PLANNING CONSULTATION RESPONSE

Application No	<u>2026/0327</u>
Proposal	Installation of black metal archway
Address	Armed Services Walkway, Westgate, Barnsley
Date of Consultation Reply	25/06/26
Consultee	Highways Development Control

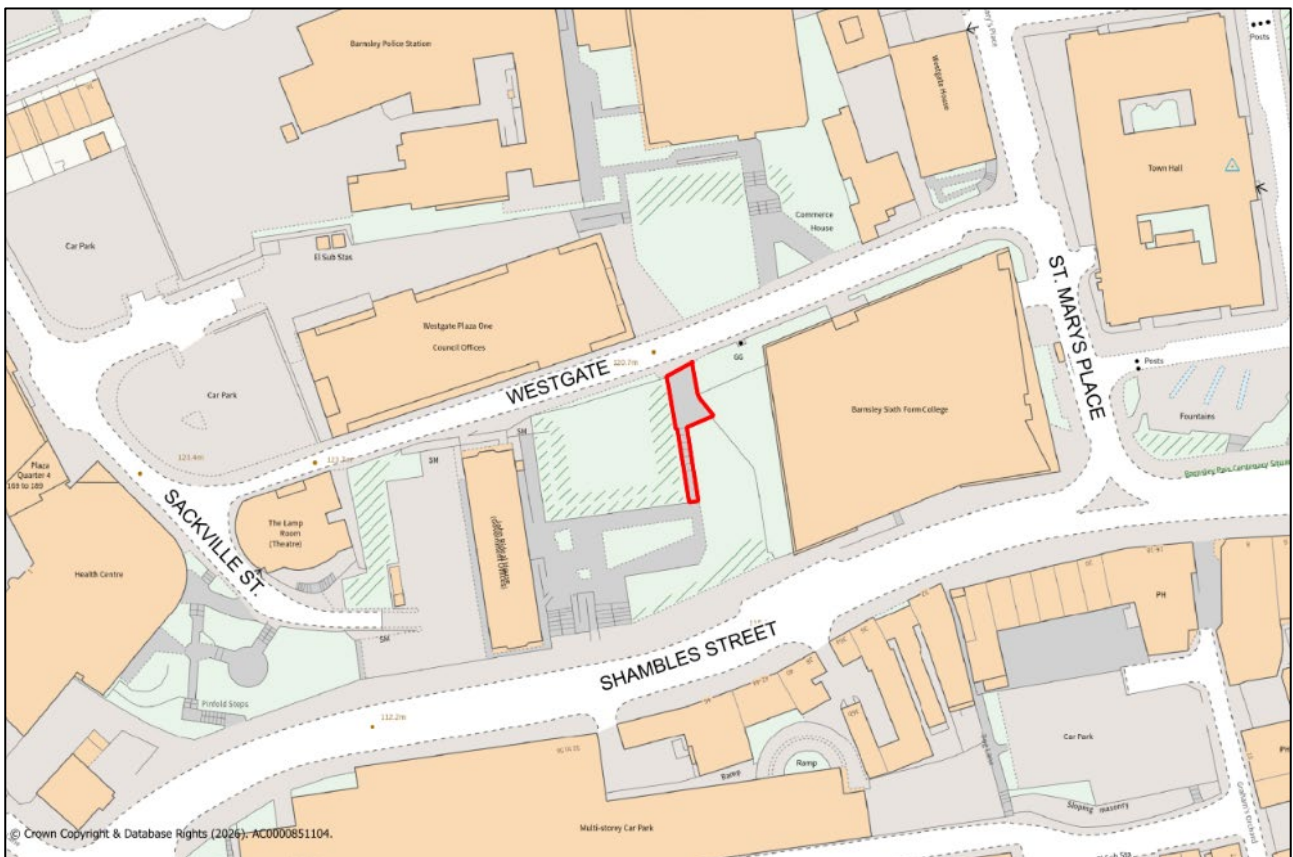
Further to the request for detailed information as to how the archway will be secured, we were provided with the following information;

This has been reviewed by our structures team who have no objections to the proposal.

- The structure will be secured to the concrete plinth at the top of the staircase.
- Metal brackets will then be installed, passing through the timber cladding and fixing into the concrete behind (several sections of cladding have already been removed to confirm this is feasible).
- If additional structural support is required, a concrete base plate can be installed to anchor the archway into the ground. Provision has been made within the budget should this be necessary.
